Consultee Comments for Planning Application 21/01993/FUL

Application Number: 21/01993/FUL

Proposal: Change of use and extension of redundant agricultural building to form 2no dwellings, demolition of polytunnel and erection of detached garage, access and associated works

On Behalf Of: Waste Management

Title:  
 Proposed Site Plan

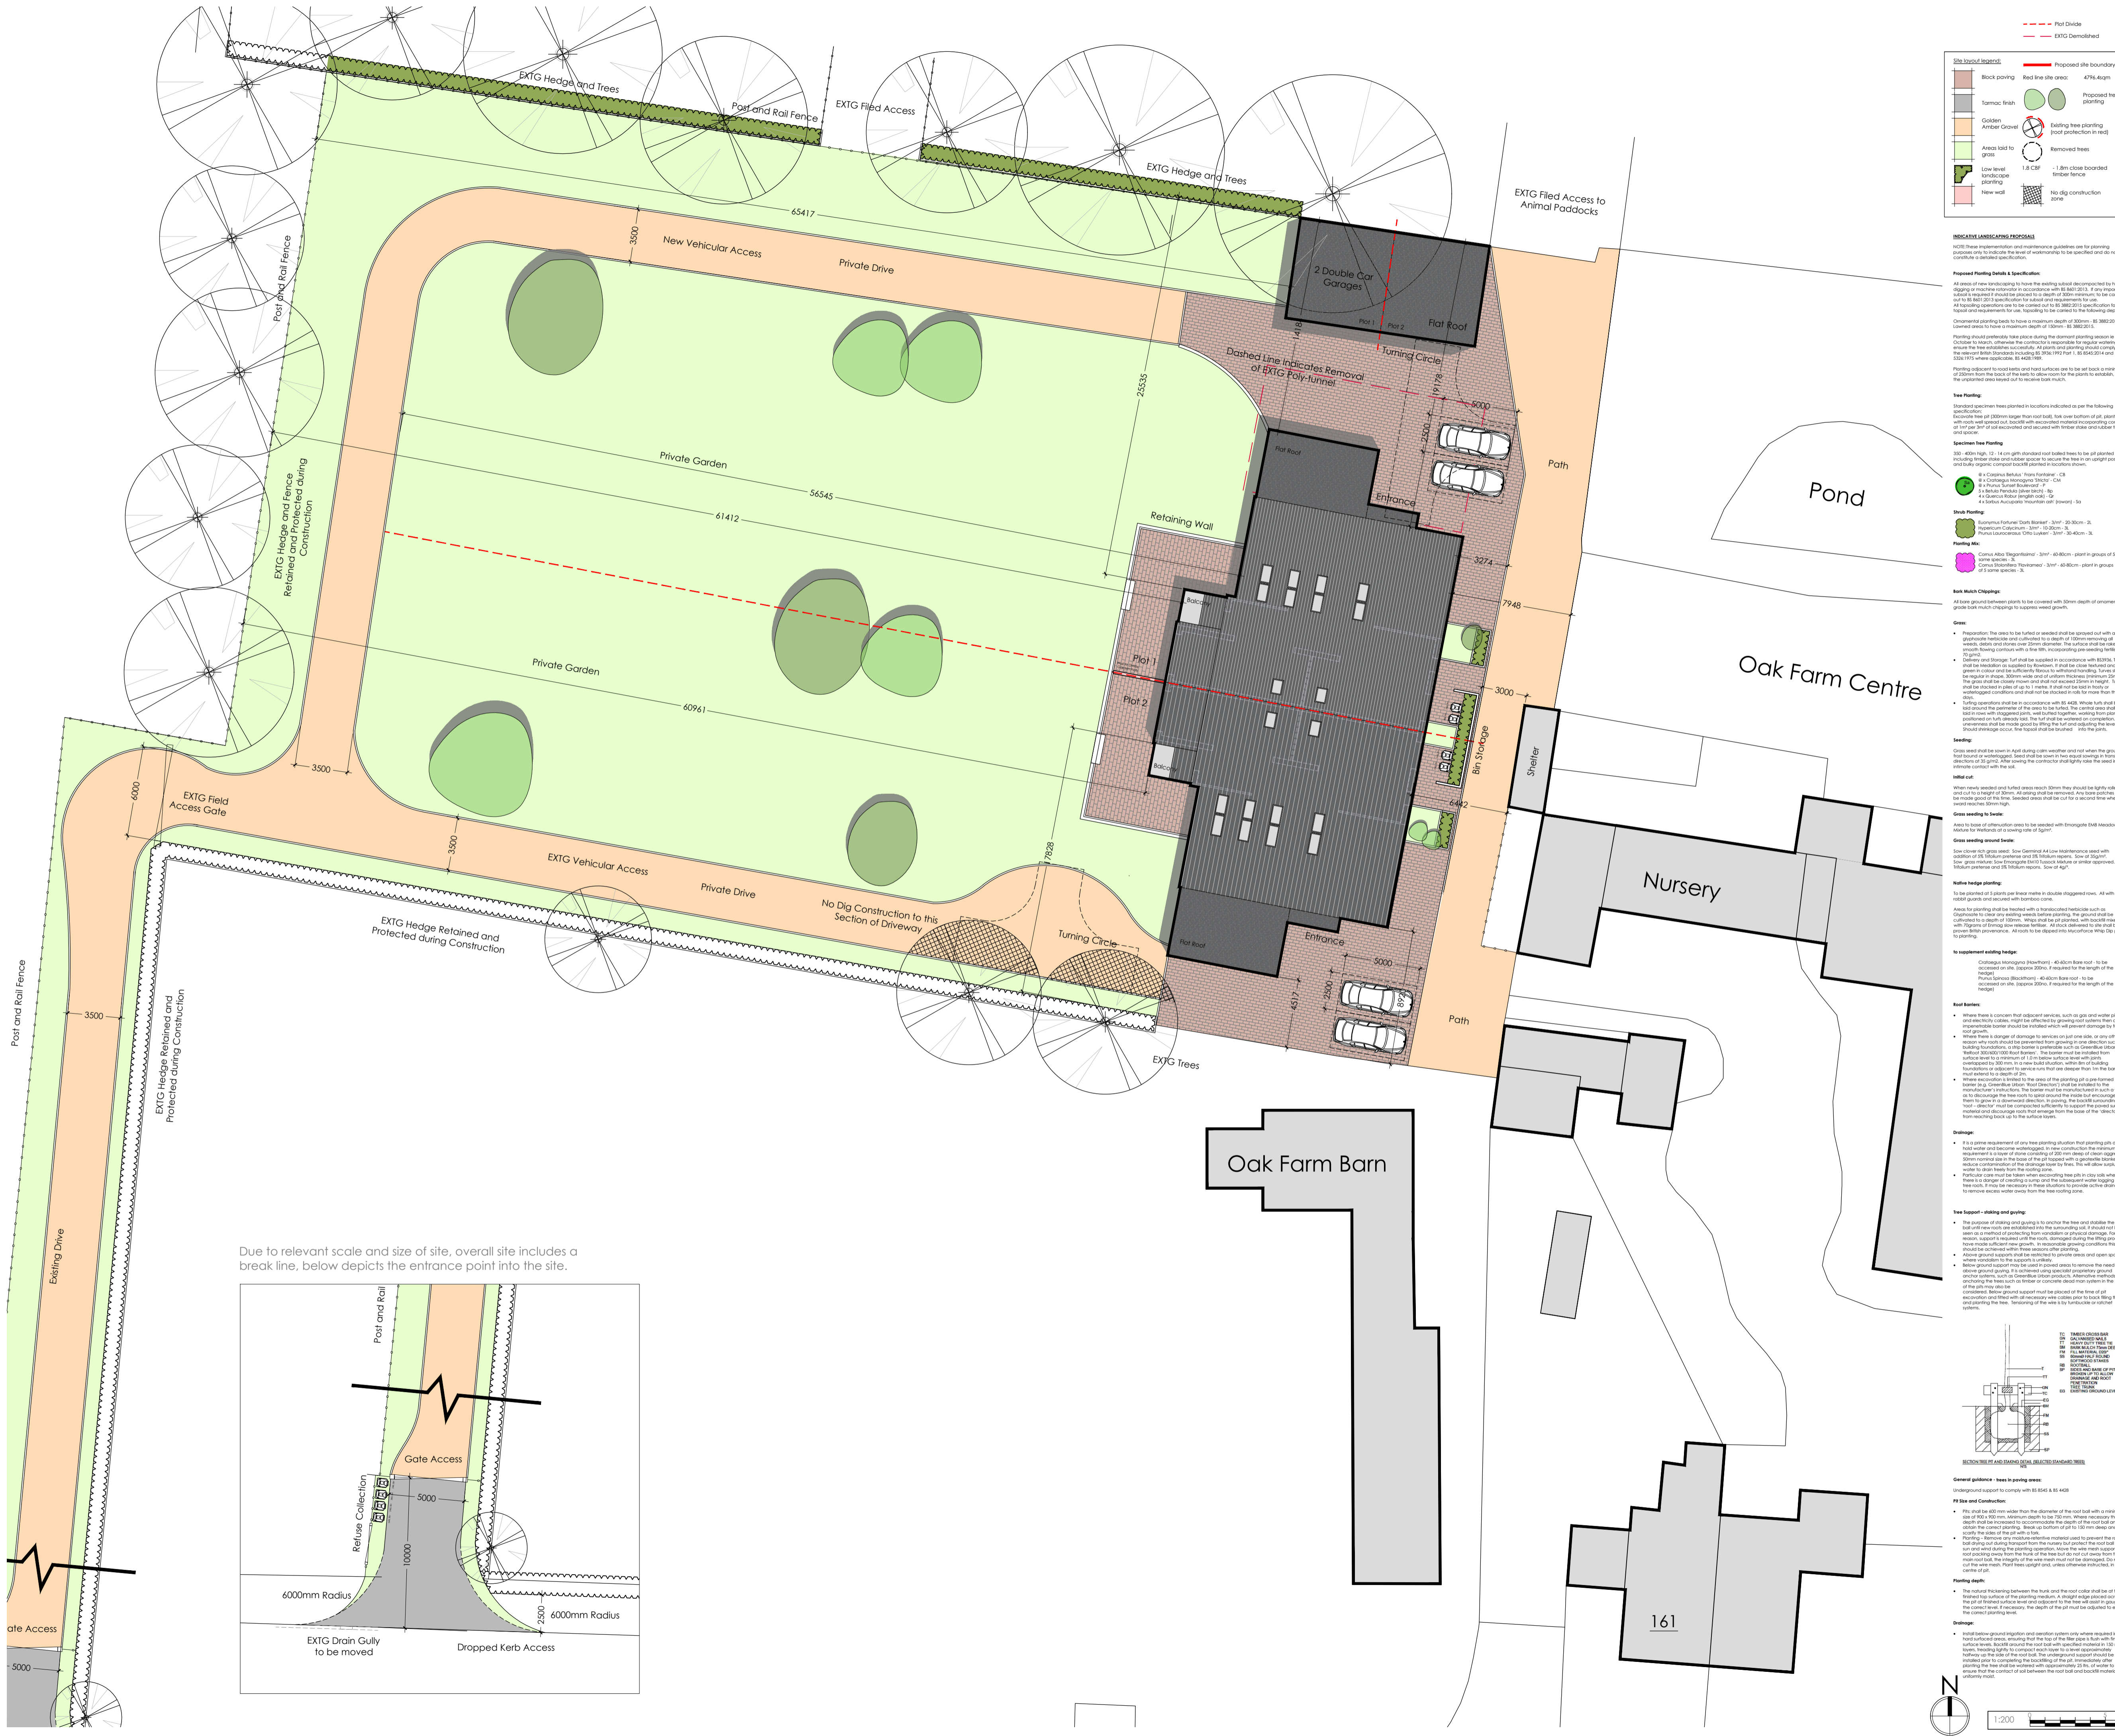
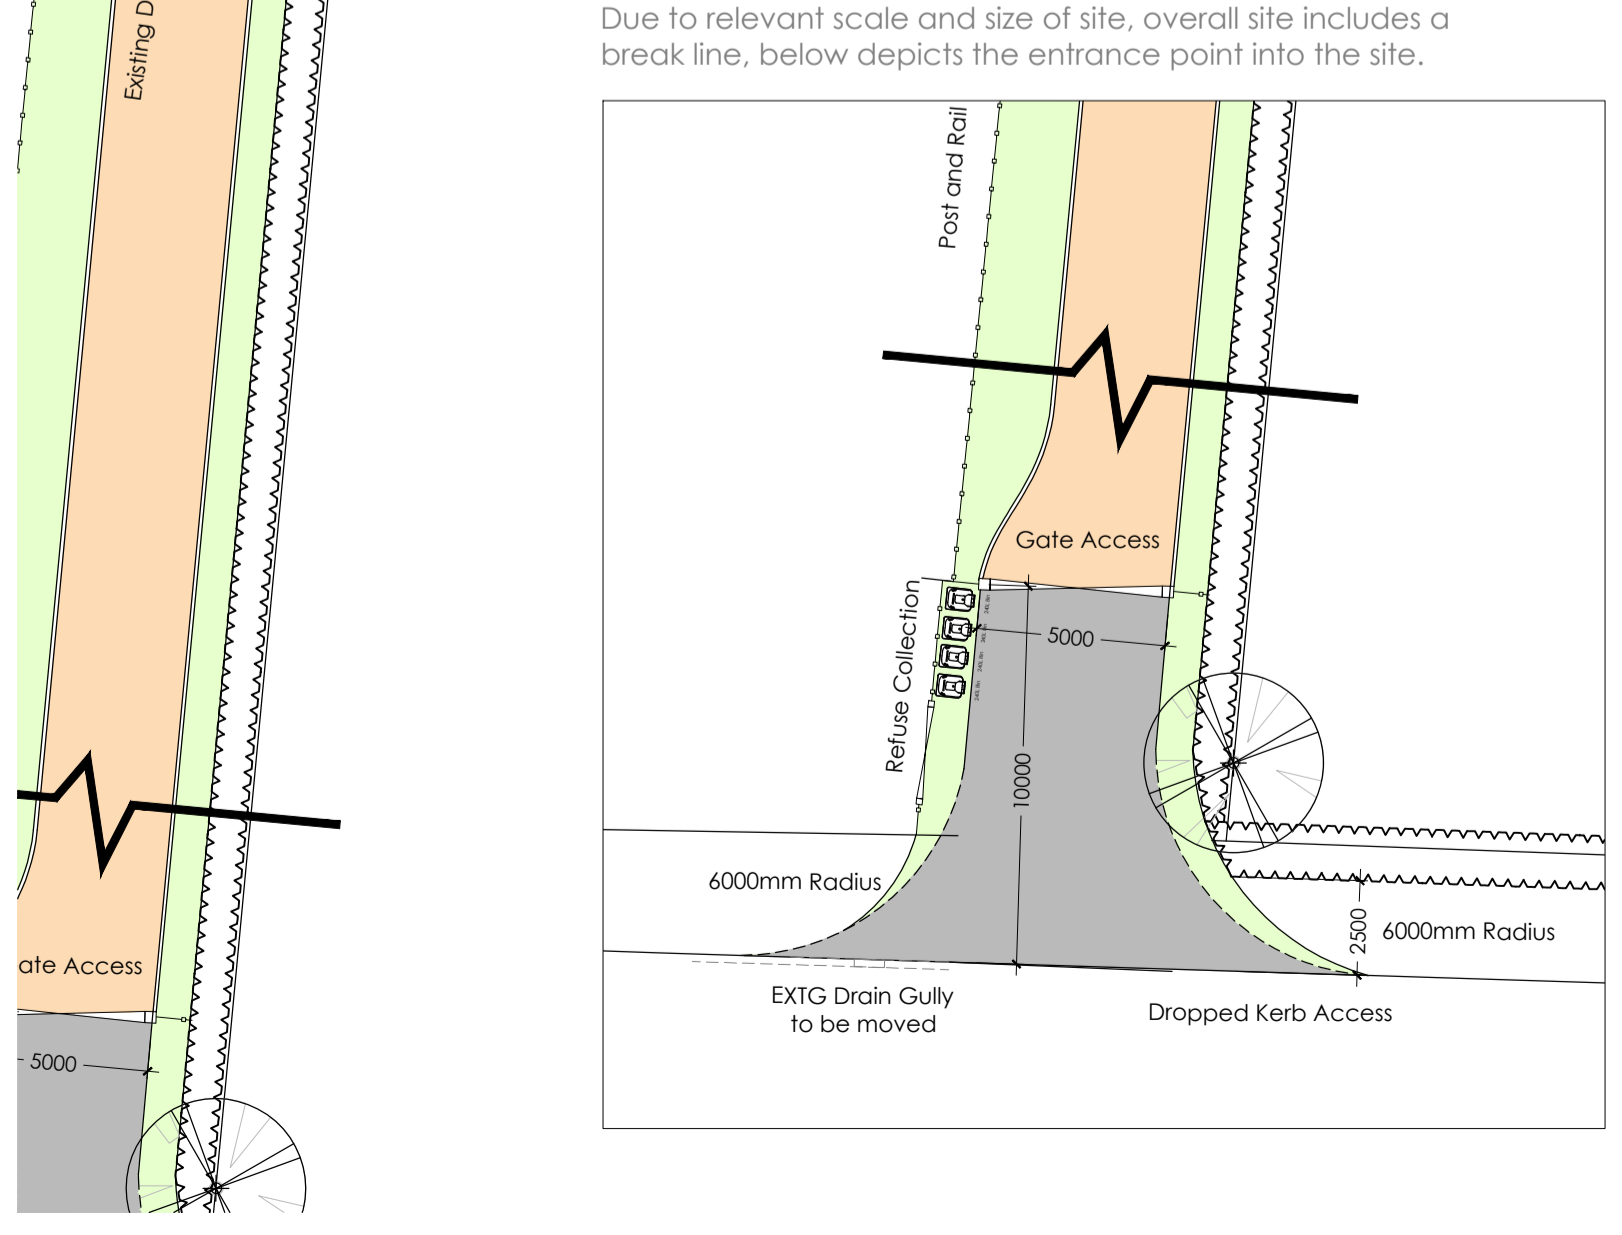
Developments of individual houses must include unobtrusive areas suitable to accommodating at least 3 x 240l wheeled bins.

The Joint Waste Service provides a kerbside collection service, therefore residents will be expected to present their bins at the nearest appropriate highway on collection days.

Unadopted roads/drives cannot be accessed by a collection vehicle if they are not constructed to an adoptable standard. Therefore a suitable bin collection point (BCP) may be required . The BCP can be a simple paved area but it must be sufficient to accommodate 3 x 240l bins for every property served by the private drive and be adjacent to the adopted highway to ensure an efficient refuse/recycling operation takes place. The inclusion of this in the plans is noted.
